Project Name: **Infinity Federal Credit Union, including one-lane drive-through**
Project ID: #2016-203
Address: 29 Baxter Boulevard CBL: 112/F11/1
Applicant: Ryan Wing, Infinity Federal Credit Union
Planner: Jean Fraser

On November 23, 2016, the Planning Authority approved with conditions a Level II site plan for the construction of a new 2,834 sq ft building for the Infinity Federal Credit Union at 29 Baxter Boulevard, Portland. The building includes a one-lane drive through as permitted in the B2 zone, and the project includes 11 parking spaces.

The decision is based upon the application, documents and plans submitted by Pinkham and Greer Civil Engineers (Civil Plan Set dated 11.15.2016) and Didonato Architects (Architectural Plans dated 11.7.2016). The proposal was reviewed for conformance with the standards of Portland's site plan ordinance.

C1.2

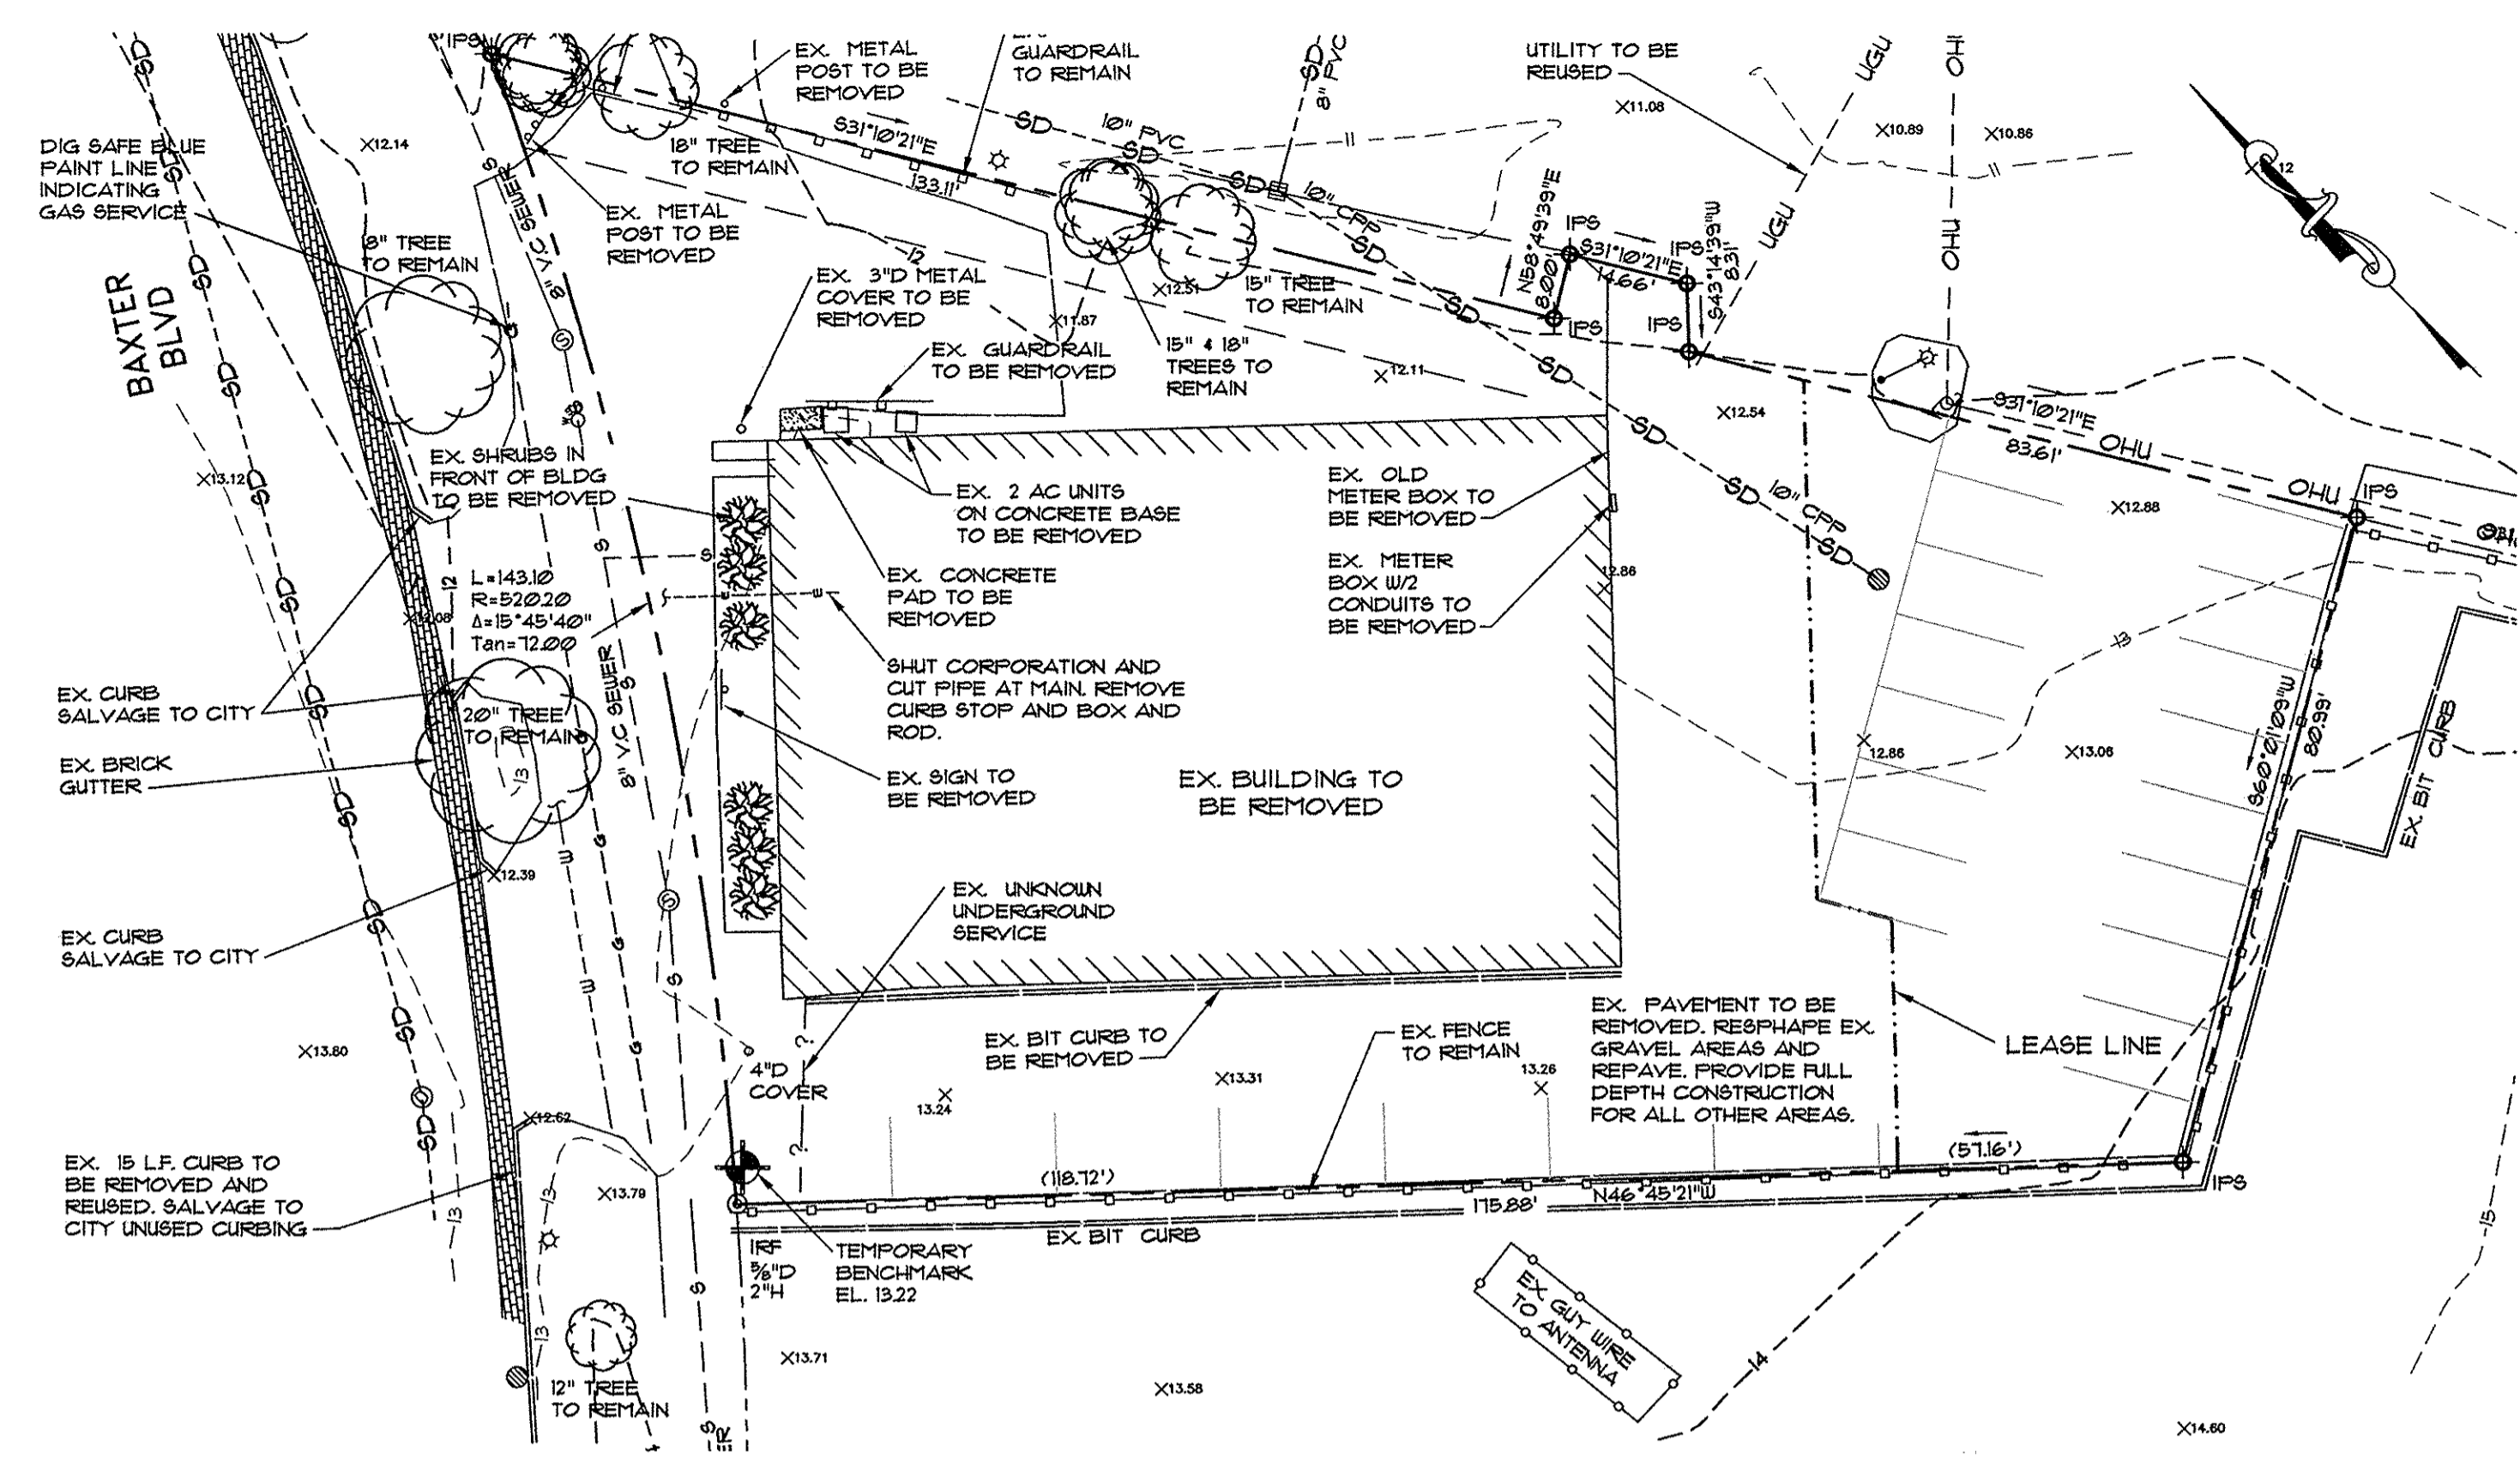
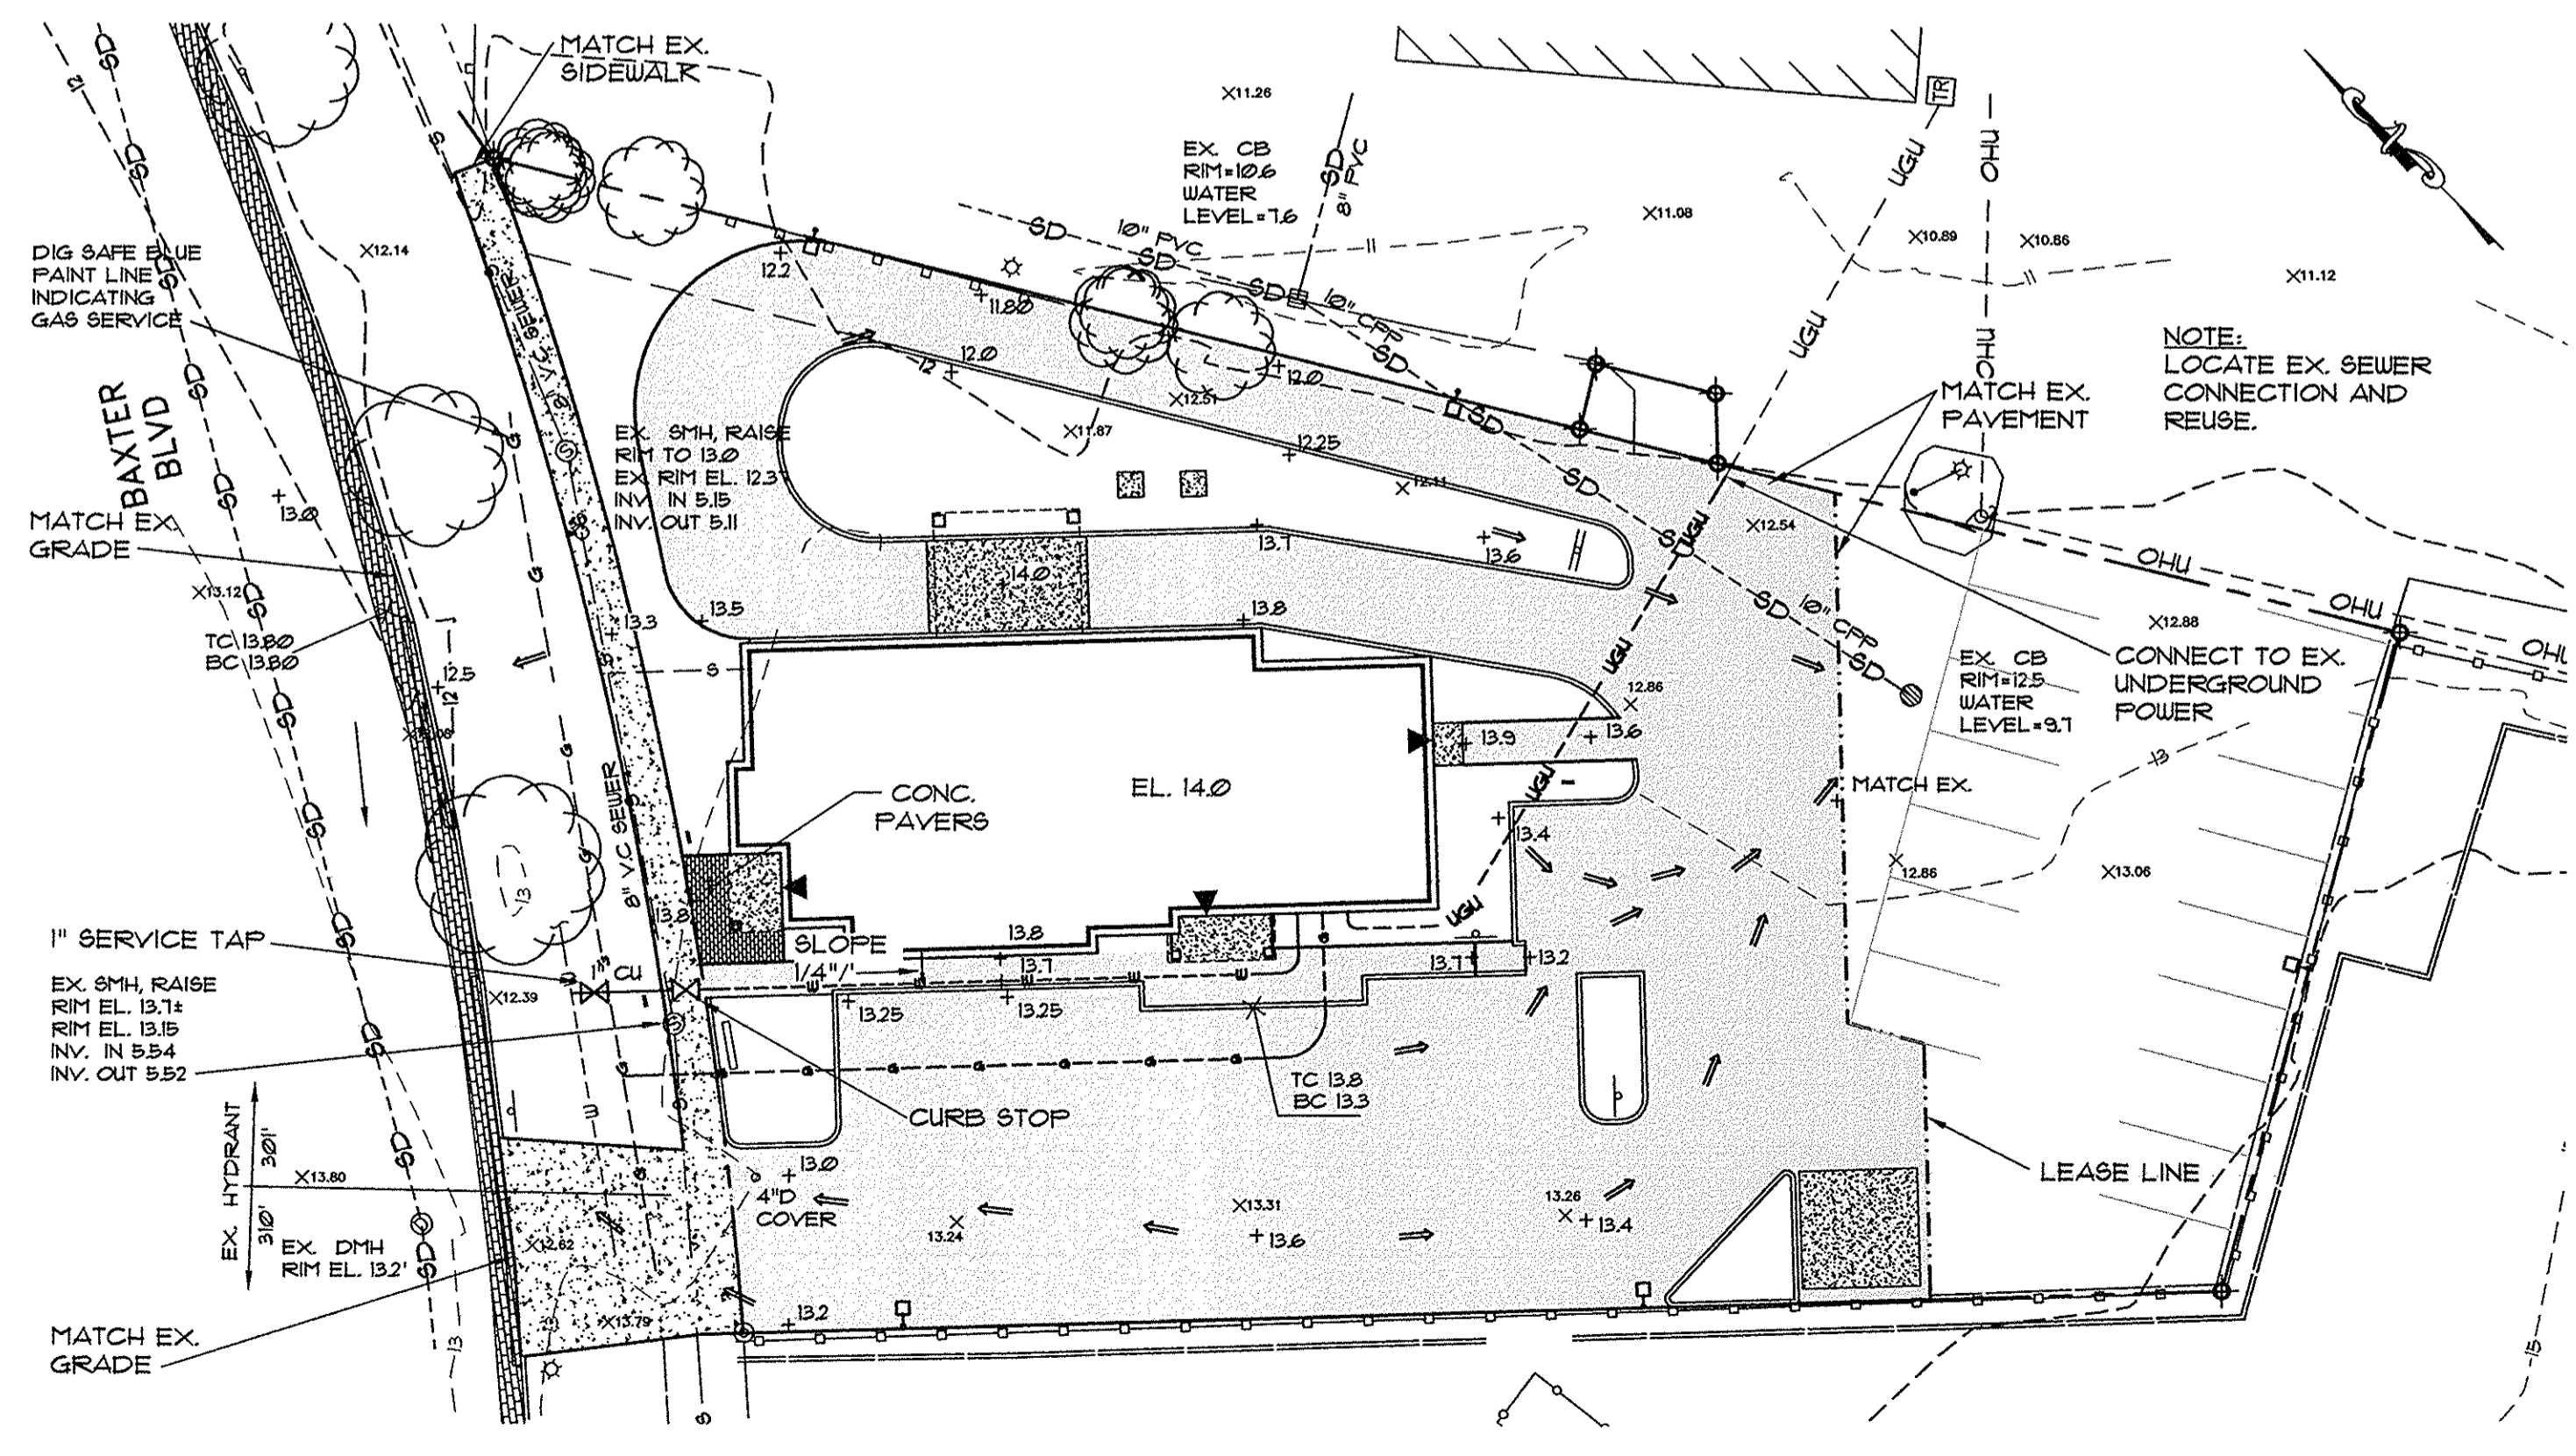
- iv. That the applicant shall revise Detail Plans C2.1 and C2.2 (both Rev 11.15.16) to show a maximum of 2% cross slope for the sidewalk, including where it crosses the driveway apron, for review and approval by the Planning Authority prior to the issuance of a building permit; and
